22 September 2021

Karen Harragon
Director, Social and Infrastructure Assessments
School & Infrastructure Assessments
NSW Department of Planning, Industry and Environment
4 Parramatta Square, 12 Darcy Street Parramatta 2150

RESPONSE TO SUBMISSIONS UNSW HEALTH TRANSLATION HUB (SSD-10822510)

8 June 21 - 4pm
CD305 SCALE: 1 : 2000

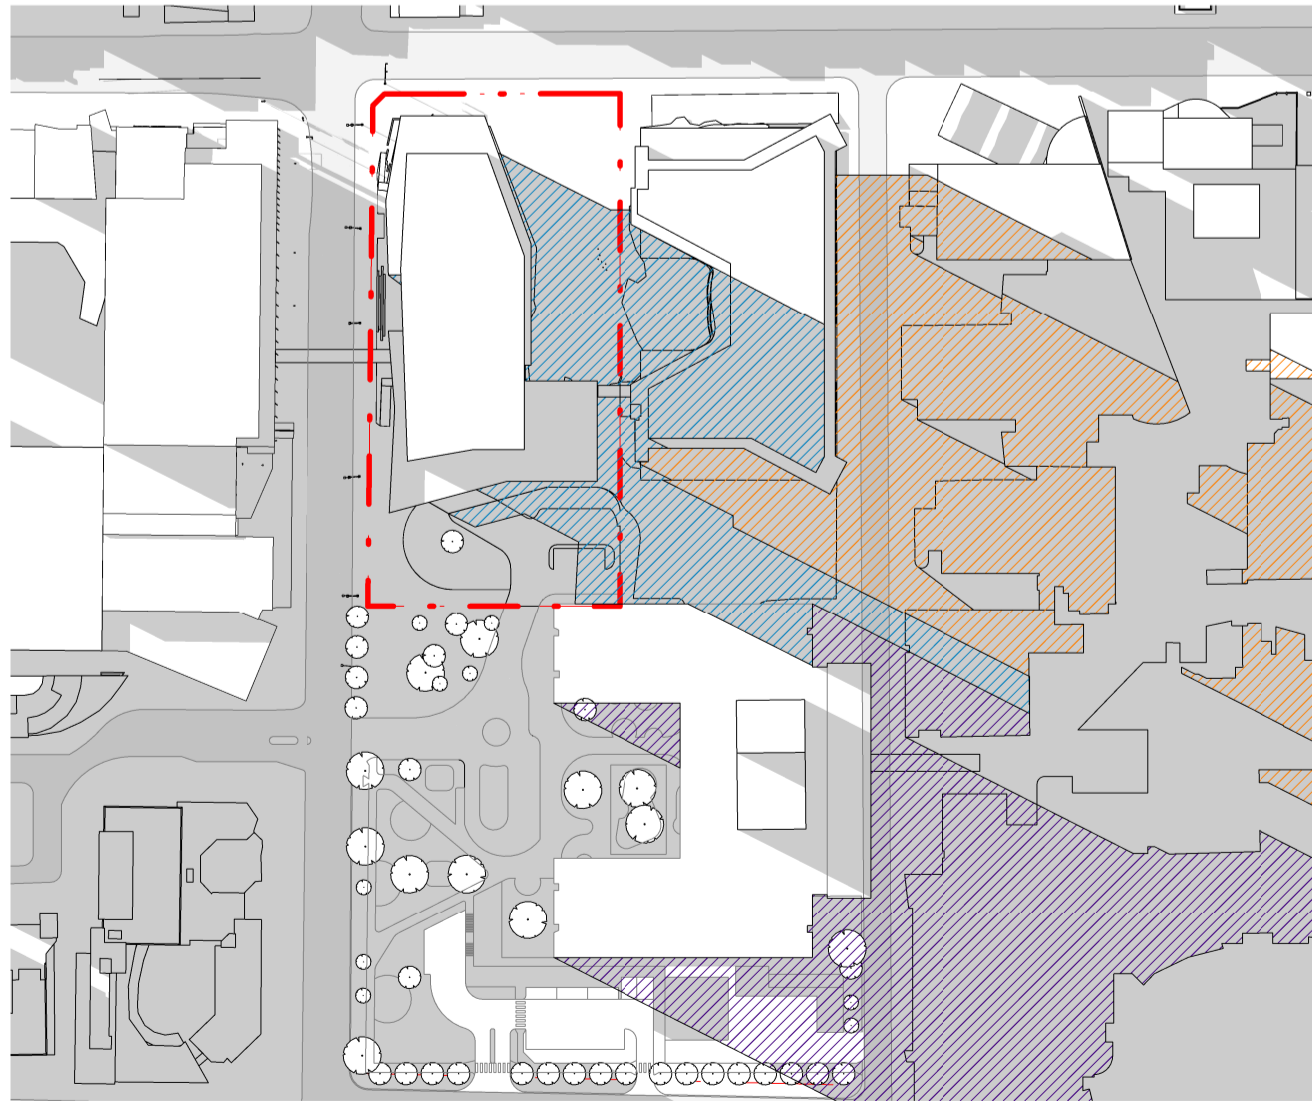
Council has requested hourly shadow diagrams at June 21 to demonstrate the overshadowing impact of the UNSW HTH on the IASB forecourt and main hospital vehicular drop-off / pick-up, which Council has identified as providing an important new green space along Botany Street for the enjoyment of Randwick Hospital, the UNSW campuses and the broader Randwick community. Council has noted that it appears as though the southern leg of the UNSW HTH will overshadow the Children's Hospital emergency vehicular drop off loop and pedestrian waiting area for most of the winter months.

In response, Architectus has prepared hourly shadow diagrams at June 21 (refer to **Attachment A** and **Figure 4**). The shadow diagrams distinguish between shadows cast by the UNSW HTH, SCH Stage 1 and CCCC and the IASB. They also show the location of the internal road network and vehicular drop-off / pick-up. The summary below demonstrates the, on balance, the shadow cast by the UNSW HTH on the green space along Botany Street is acceptable as it does not cast significant shadow on this space between 12:00pm and 3:00pm on the Winter Solstice.
